The Burnet Heritage Trust's (BHT) response to ExQ1 (issued Friday 9th May 2025), including.

- Comments relevant to Question 1.6.1
- An answer to Question 1.6.2
- Comments and new information relevant to Question 1.6.8
- Comments and new information relevant to Question 1.6.9.
- Comments relevant to Question 1.6.18
- Comments relevant to Question 1.6.20 and 1.6.21

AECOM

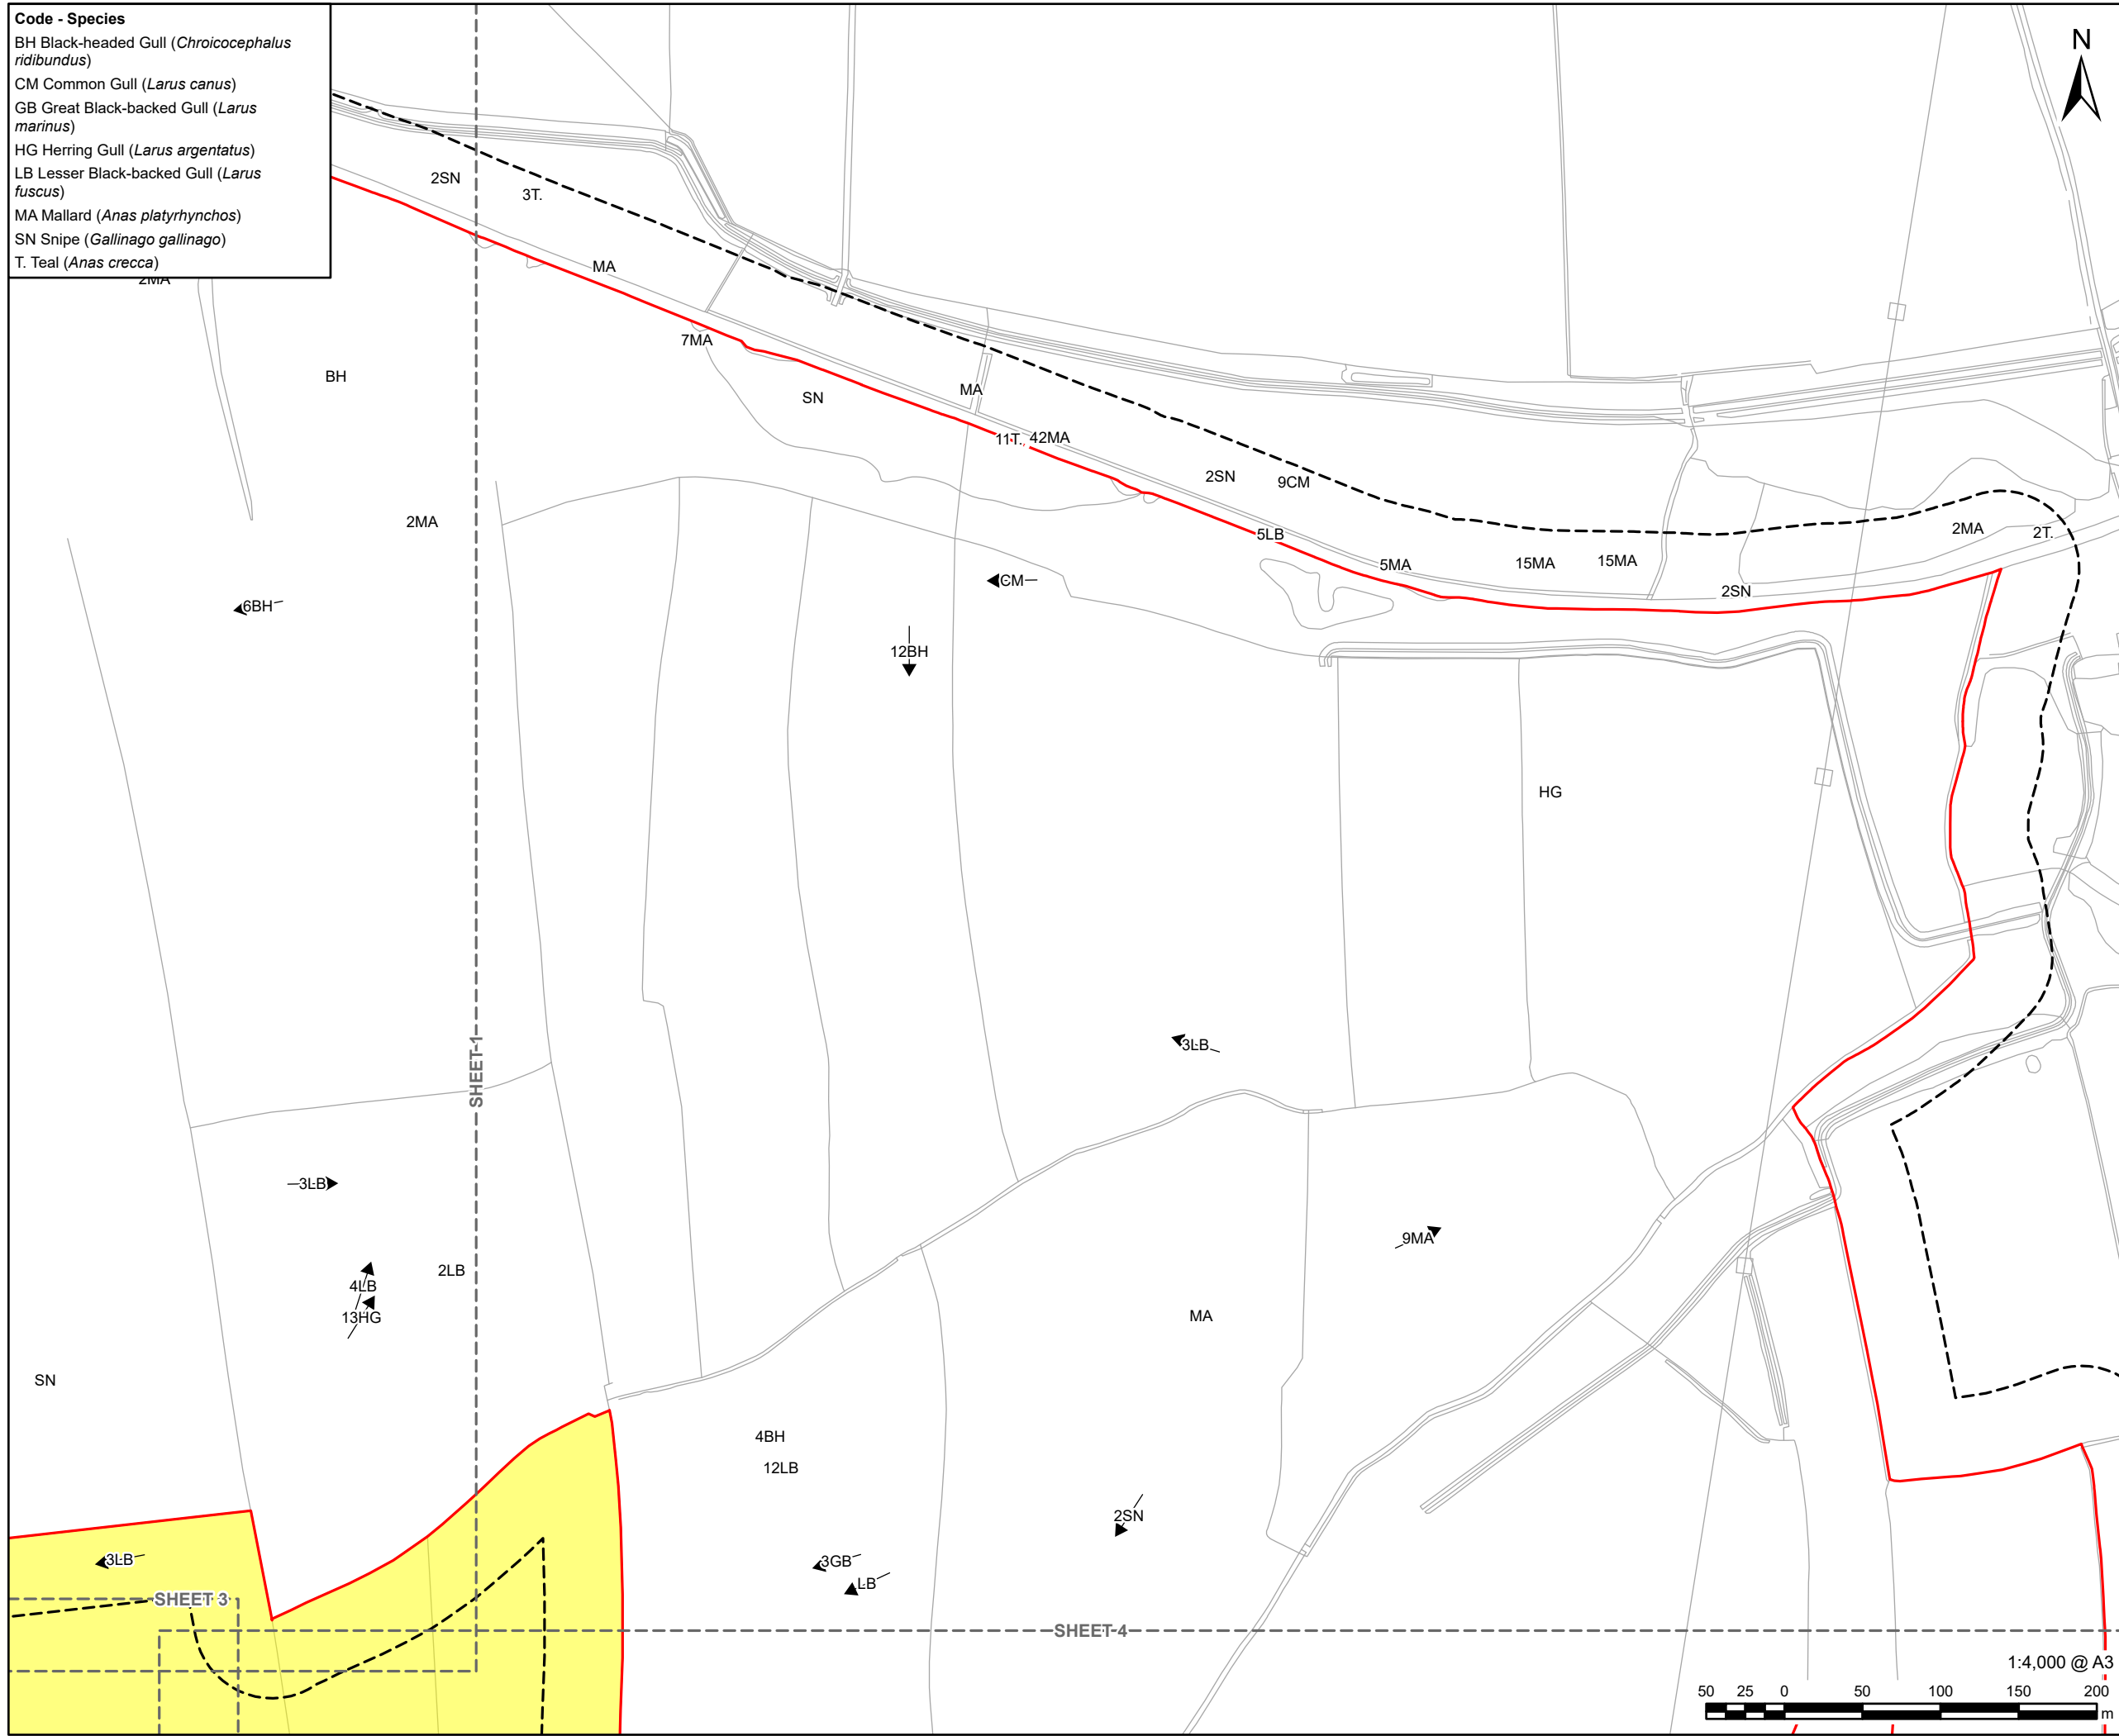
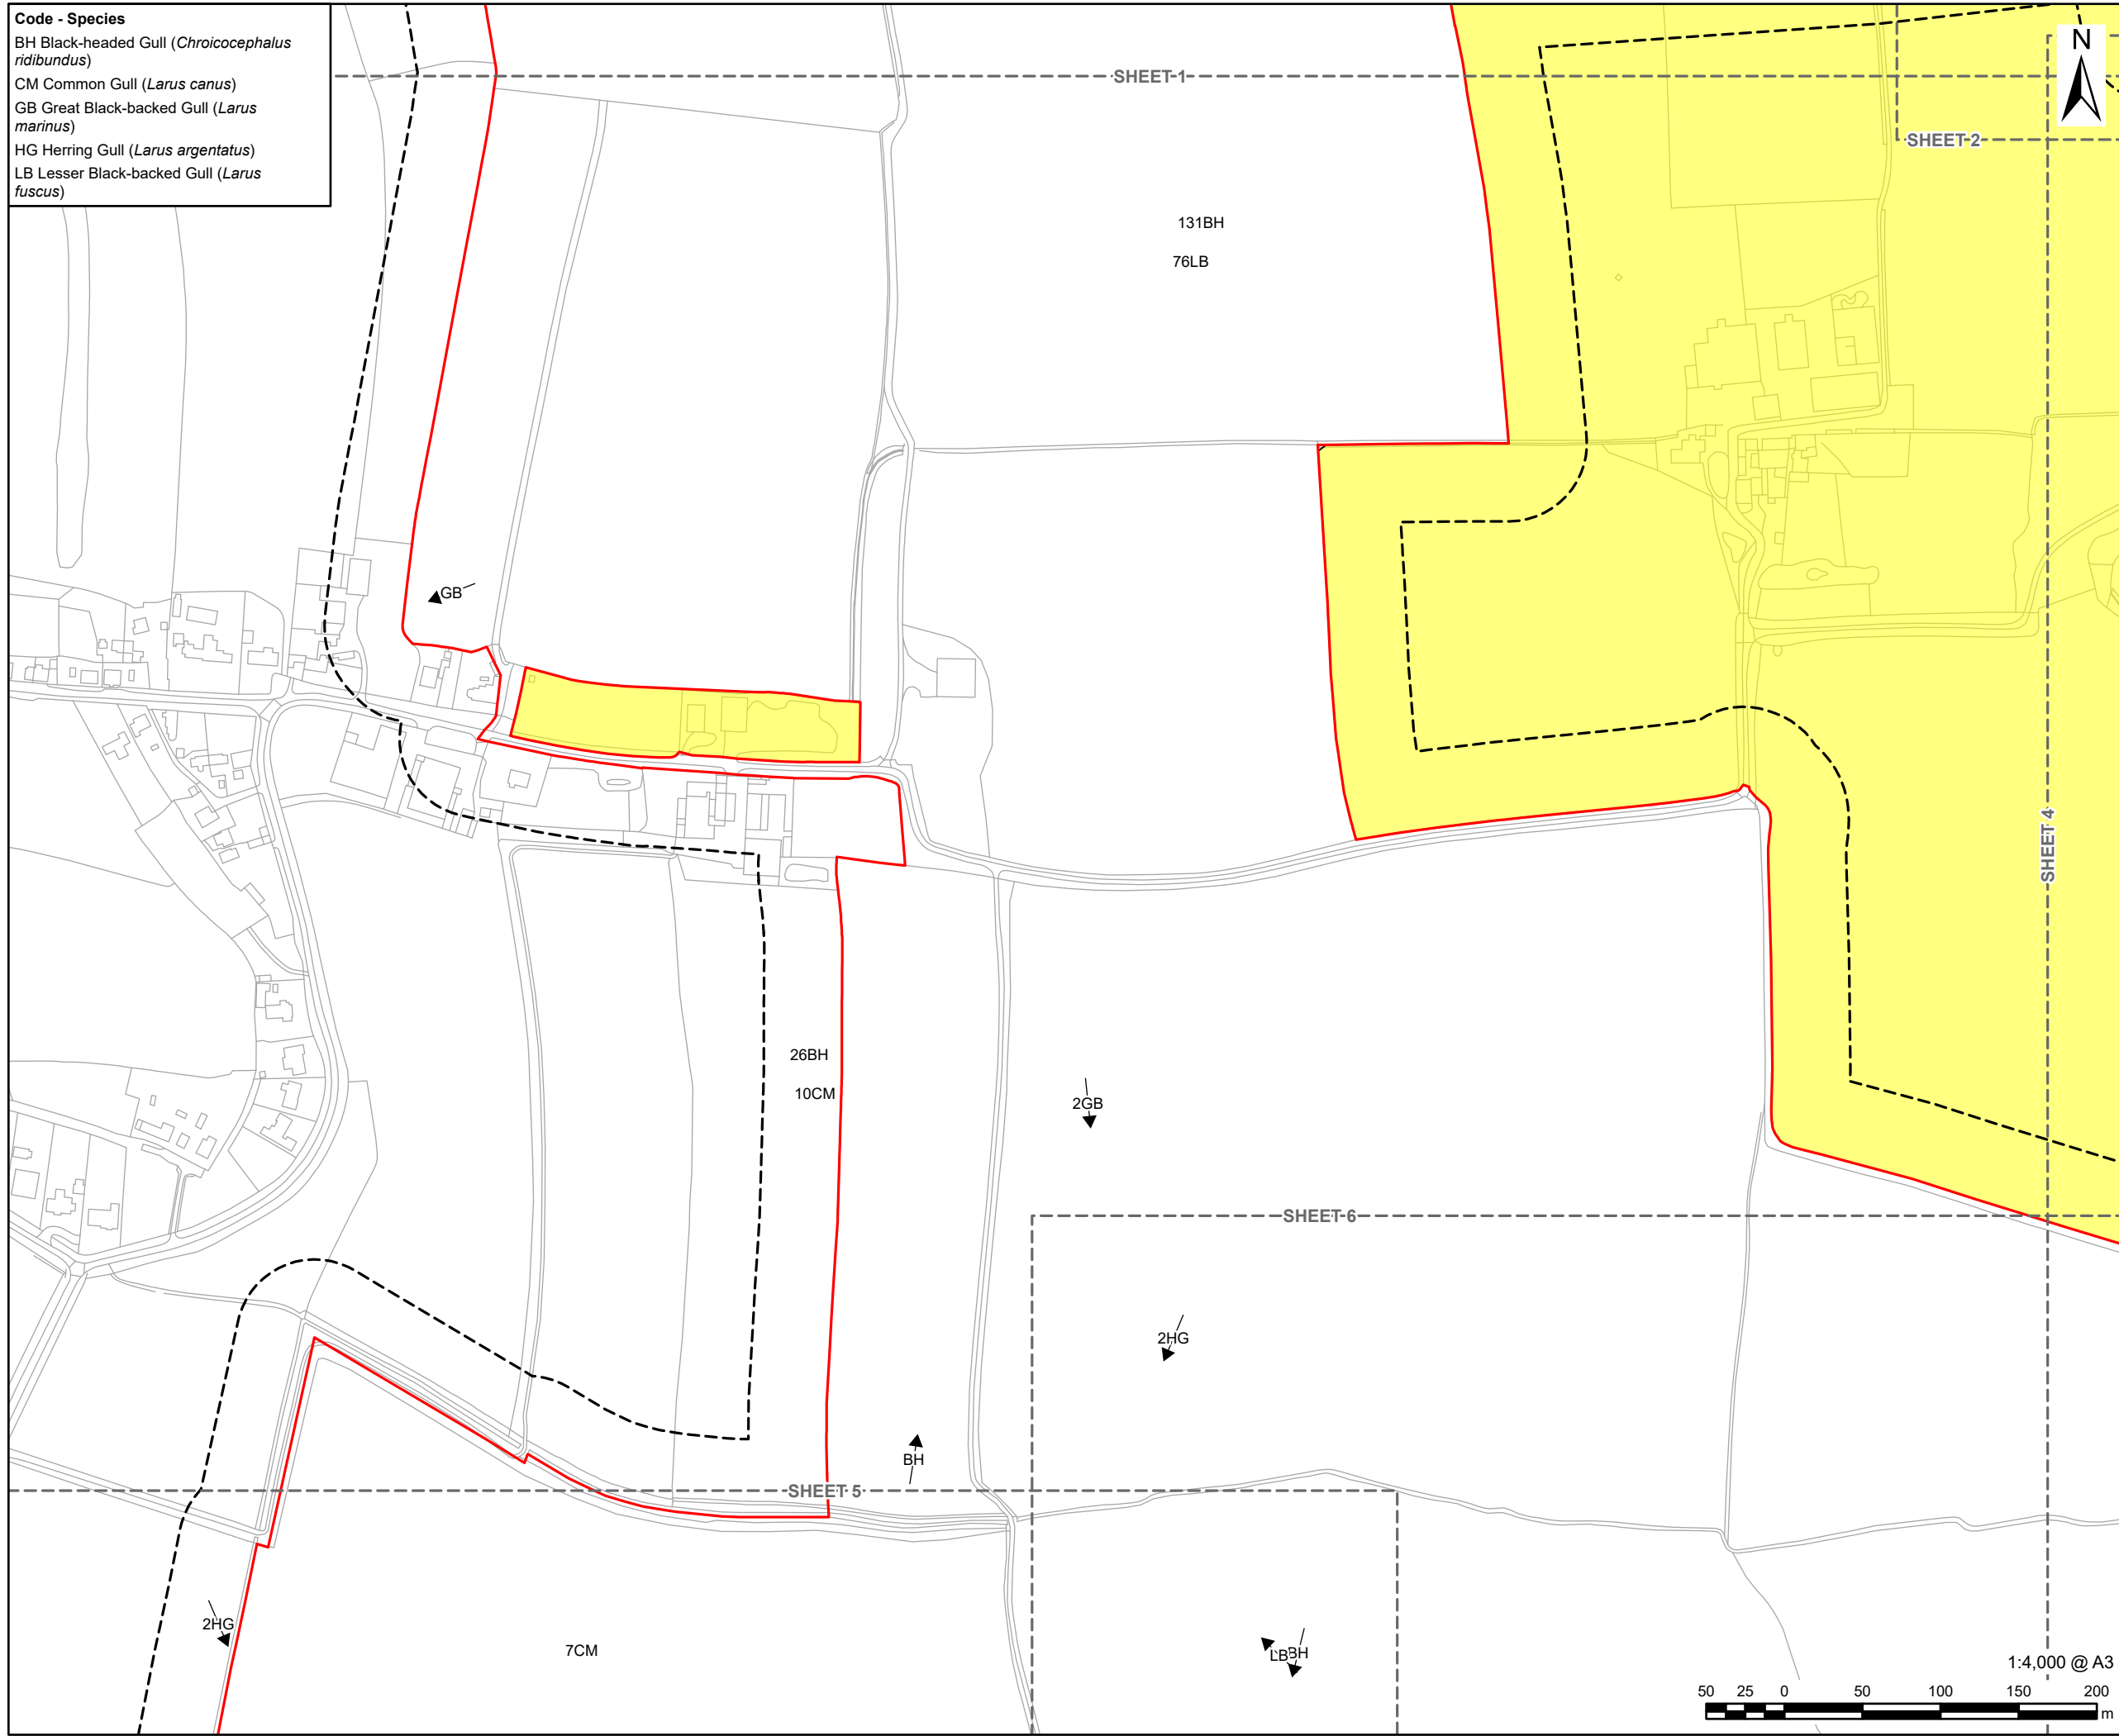
Ref:	Question to:	Question:
1.6.8	Applicant	<p>The Burnet Heritage Trust have commented [RR-011] there are a number of species that have not been surveyed or included within ES Appendices 8-7 [APP-152 and APP-153] and 8-8 [APP-154] as follows:</p> <ul style="list-style-type: none"> • Table 4 of ES Appendix 8-7 states that Marsh Harrier is not within the order limits. As Marsh Harrier is identified within Annex 1 Birds of Conservation Concern (BoCC) Amber list, please confirm survey distance for this species given the methodology set out within Section 3 of ES Appendix 8-7 and given the ecological protection afforded this species. • Grasshopper Warbler have not been surveyed. Given this species is a Species of Principal Importance (SPI) and is listed on the BoCC Red list, please confirm the extent of the surveying distance for this species given the methodology set out within Section 3 of ES Appendix 8-7. • Marsh Warbler have not been surveyed. Please confirm if this species was surveyed and if not, why not. • Garganey have not been surveyed. Please confirm if this was surveyed and if not, why not.

The Burnet Heritage Trust; Comments relevant to Ref 1.6.8		<p>The Burnet Heritage Trust welcomes the Examining Authority's queries regarding the thoroughness of bird surveys. The Trust has provided information to direct interested parties to the sources of the relevant data (REP1-054).</p>
The Burnet Heritage Trust; New information relevant to Ref 1.6.8 and the proposed issue-specific hearing (ecology and mitigation).		<p>The Trust would again query the omission of curlew records from the applicant's surveys and the species listed above (1.6.8). The Trust has provided records on numerous occasions, and a recent EIR data request confirmed that Natural England also accepts the presence of curlew in the area.</p> <p>See attached documents: EIR202504725_24-01-24_email_Redacted EIR202504725_EIA letter_Redacted</p> <p>In correspondence with the landowner, NE asked the landowner to confirm in which of the land parcels under investigation, curlews had attempted to breed. In their letter to the landowner regarding the outcome of their investigation, they state "...we found evidence of curlew breeding in the vicinity..."</p> <p>As the Government's own conservation agency is satisfied that there is evidence of Curlew in the area, the Trust would ask that the presence of Curlew be accepted and for the Impact Assessment to be reviewed to provide the necessary mitigation.</p>
